Our ref: RA/2023/146565/04-L01
Your ref: 2023/93388

CHANGE OF USE FROM DOMESTIC TO COMMERCIAL, DEMOLITION OF EXISTING WORKSHOP AND ERECTION OF THREE STOREY OFFICE BUILDING (WITHIN A CONSERVATION AREA) – DENE END FUNERAL HOME, 50 NORTH ROAD, KIRKBURTON, HUDDERSFIELD, HD8 0RW

Thank you for re-consulting us on this application following submission of a revised FRA, which we received on 12 July 2024.

DRAWING TITLE
LOWER GROUND FLOOR - DEMOLITIONS

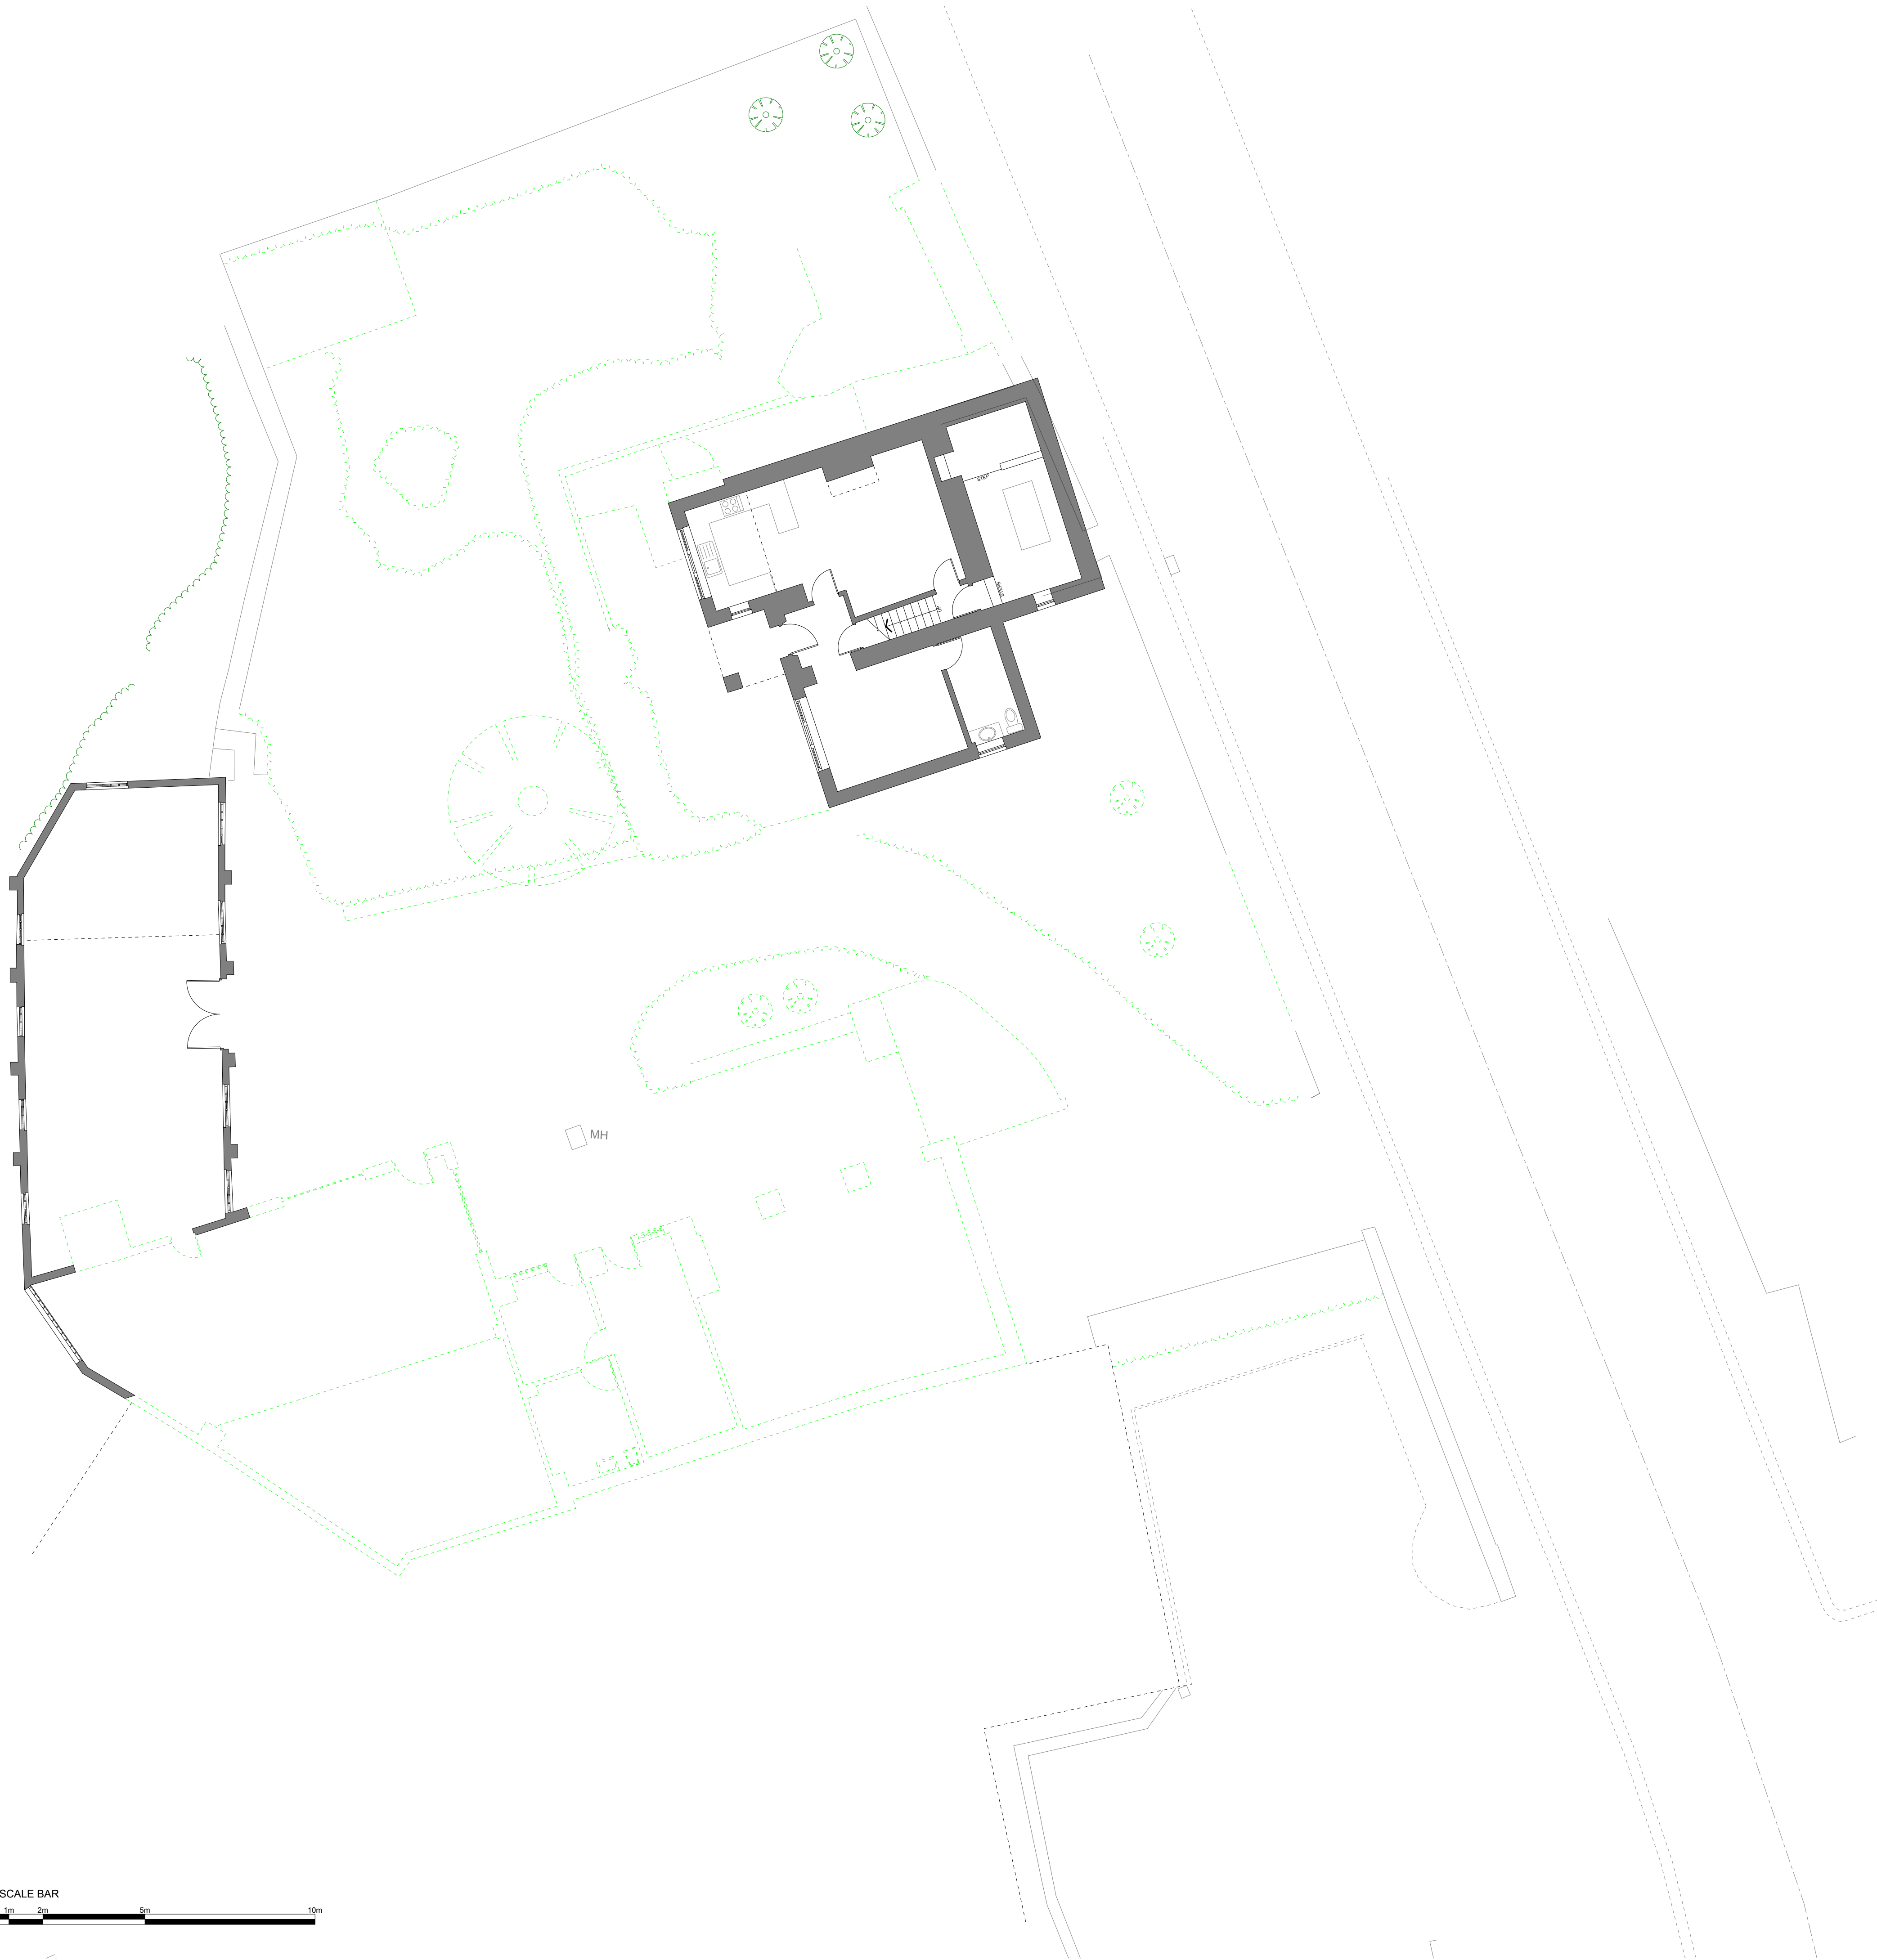
Section 2.3 of the FRA indicates that it is understood that the proposed development includes the demolition of a workshop/garage building and the construction of a three-storey office building. Part of the existing workshop/garage building is close to and over the Dean Bottom Dike main river.

It is unclear from the FRA whether the buildings over and adjacent to the watercourse are planned to be demolished or rebuilt. If they are, then it is important that the FRA demonstrates that the works can be completed without posing a risk to the structural integrity of the watercourse culvert and bank/river wall structures. Damage to the watercourse could increase flood risk.

If these buildings are only planned to be altered internally and not structurally, then this is not a concern, but needs to be clarified.
